Our ref: NO/2018/111326/01-L01
Your ref: 3/2018/1054
Date: 18 December 2018

CHANGE OF USE OF AGRICULTURAL LAND TO EXERCISE/PLAY AREA FOR DOGS. ERECTION OF SECURE FENCING AND WOODEN SHELTER/REST AREA. CONSTRUCTION OF LIMESTONE/GRAVEL AREA FOR VEHICLE DROP-OFFS AND NON-DESIGNATED PARKING USING EXISTING GATES

LAND ON THE SOUTH SIDE OF RIDDING LANE (BROAD LANE), WHALLEY, ADJ SEWAGE WORKS

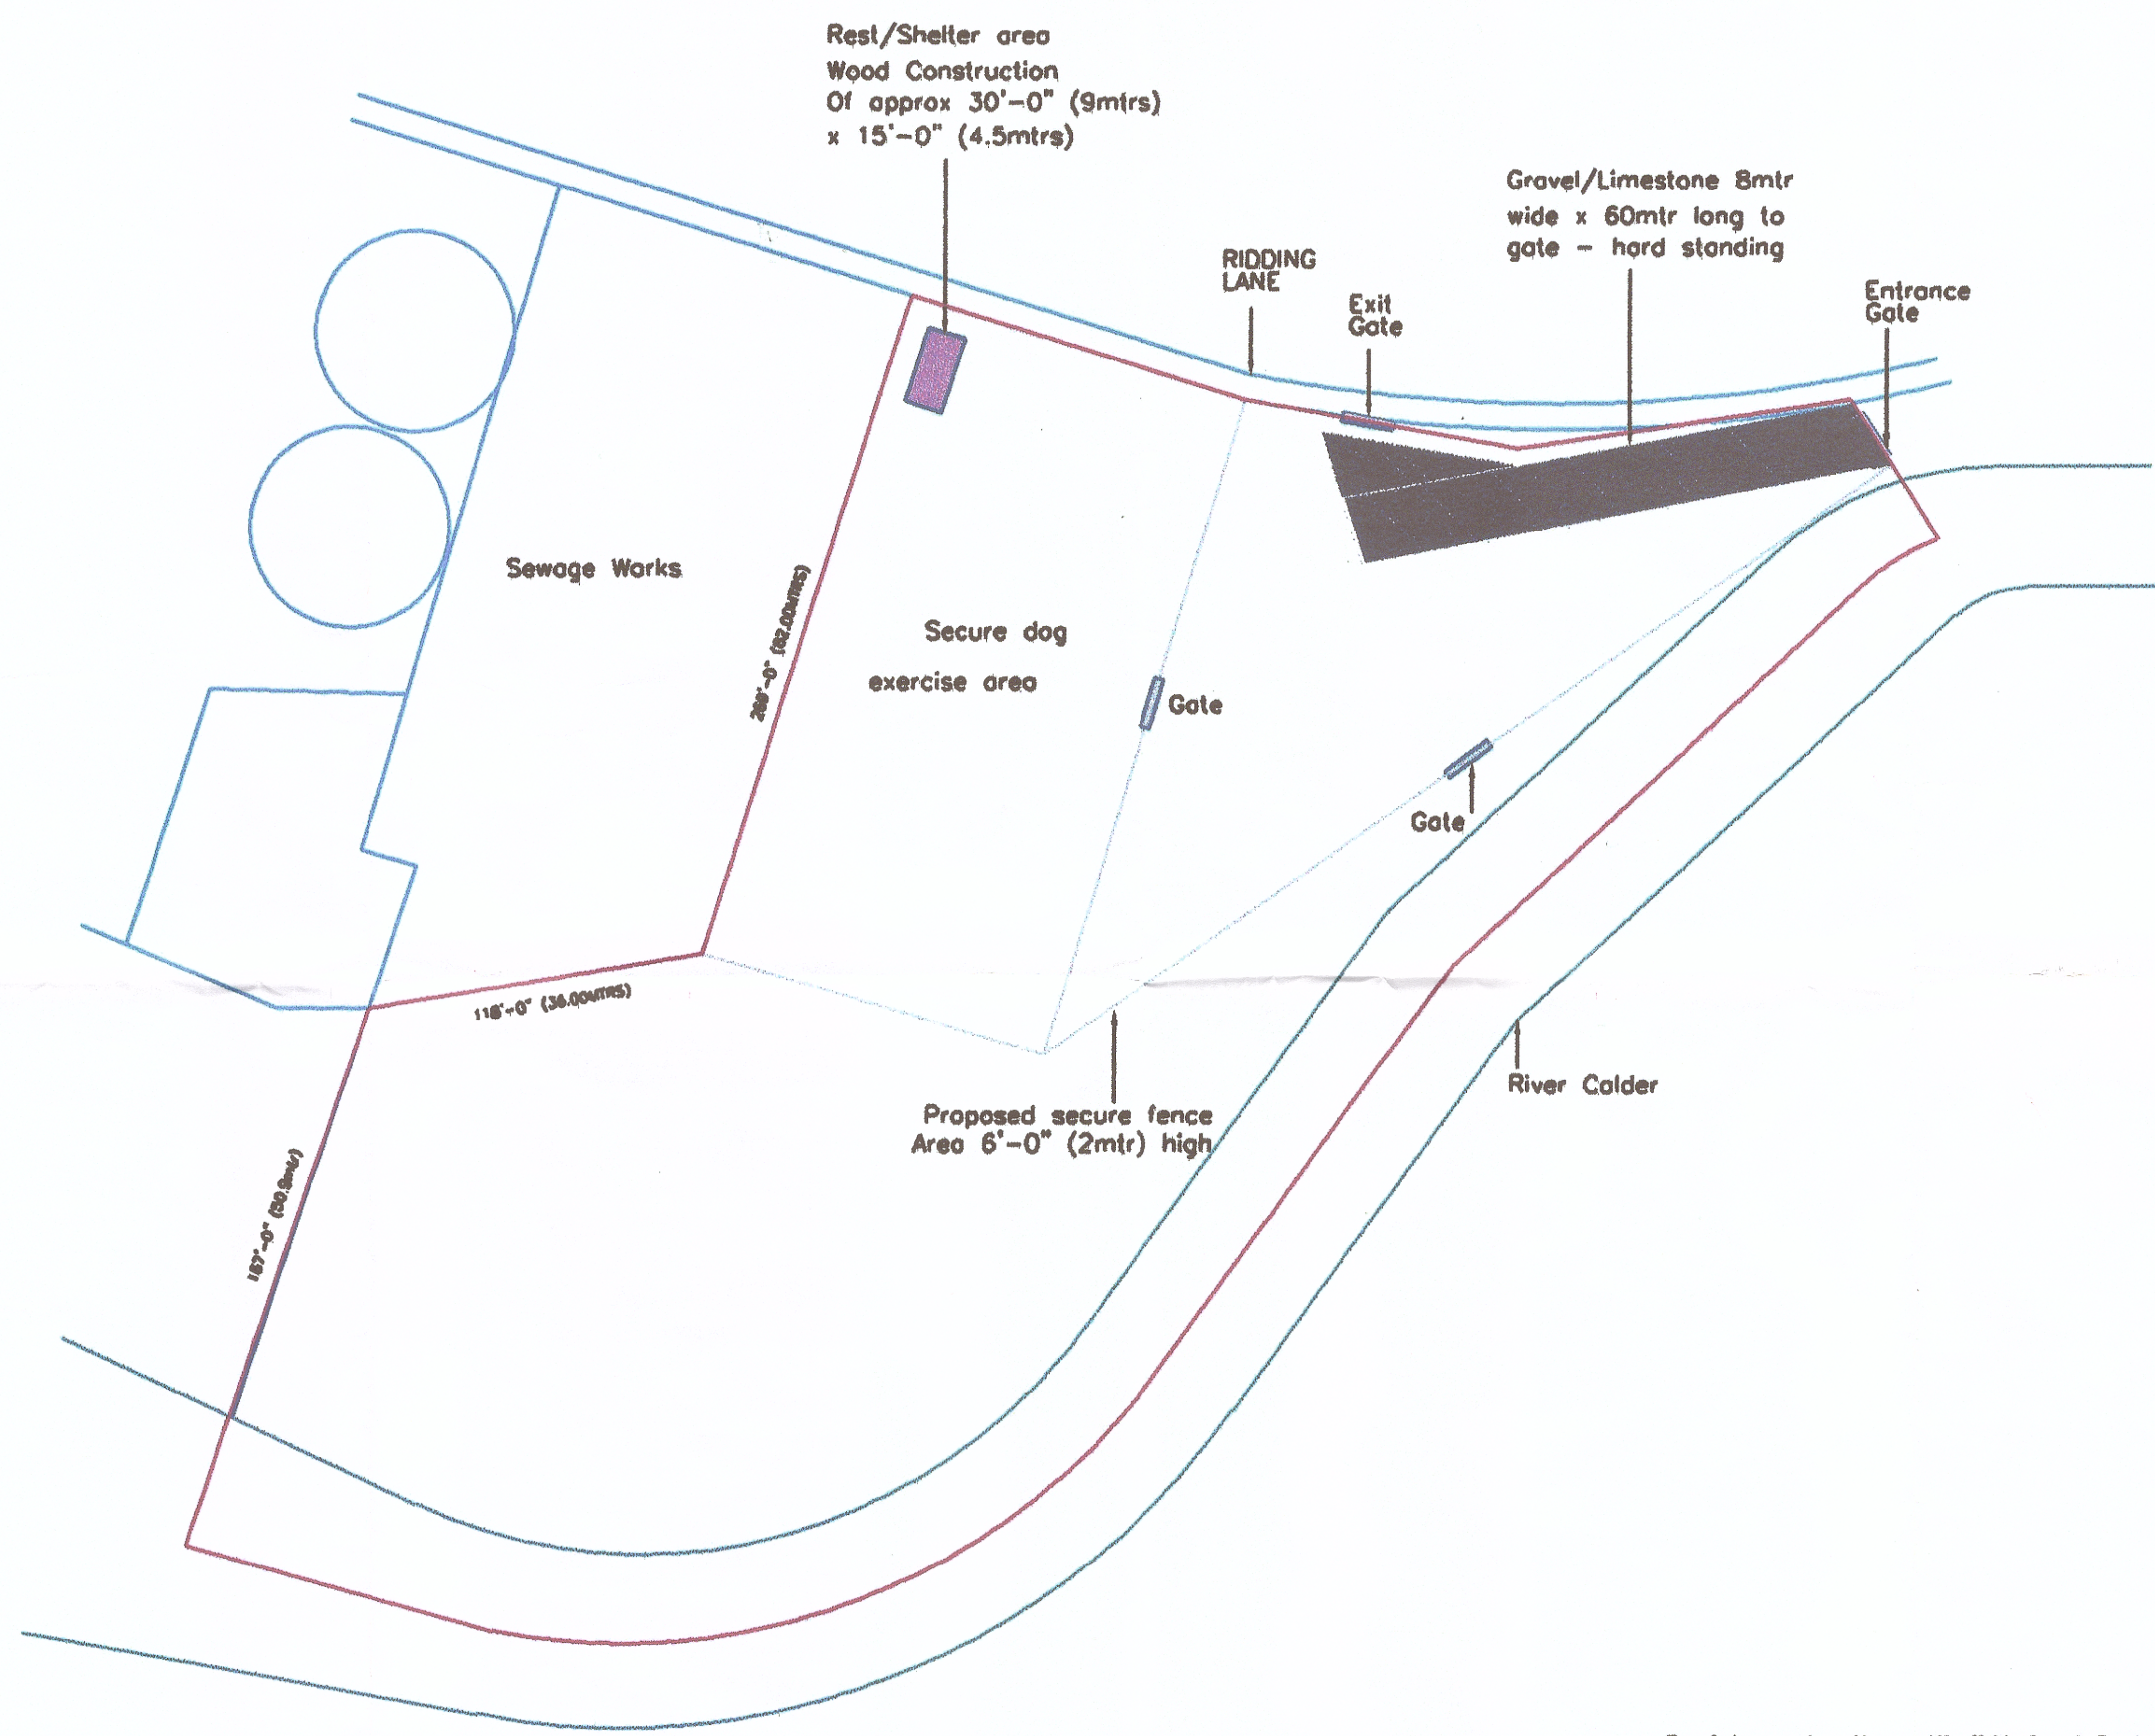
The site is surrounded by Flood Zone 3 and the only access may be cut off in a flood. This risk has not been considered. Whether or not this is acceptable is an emergency planning risk that others will need to decide.

In particular, no trees or shrubs may be planted, nor fences, buildings, pipelines (including outfalls) or any other structure erected within 8 metres of the top of the bank of the River Calder without an environmental permit.

We recommend that the applicant considers preparing a Flood Warning and Evacuation Plan (FWEP) to ensure that the appropriate course of action is taken in the event of flooding. The Environment Agency do not comment on or approve the adequacy of FWEPs or equivalent procedures accompanying development proposals, as we do not carry out these roles during a flood. Our involvement with most developments during an emergency will be limited to delivering flood warnings to occupants/users.
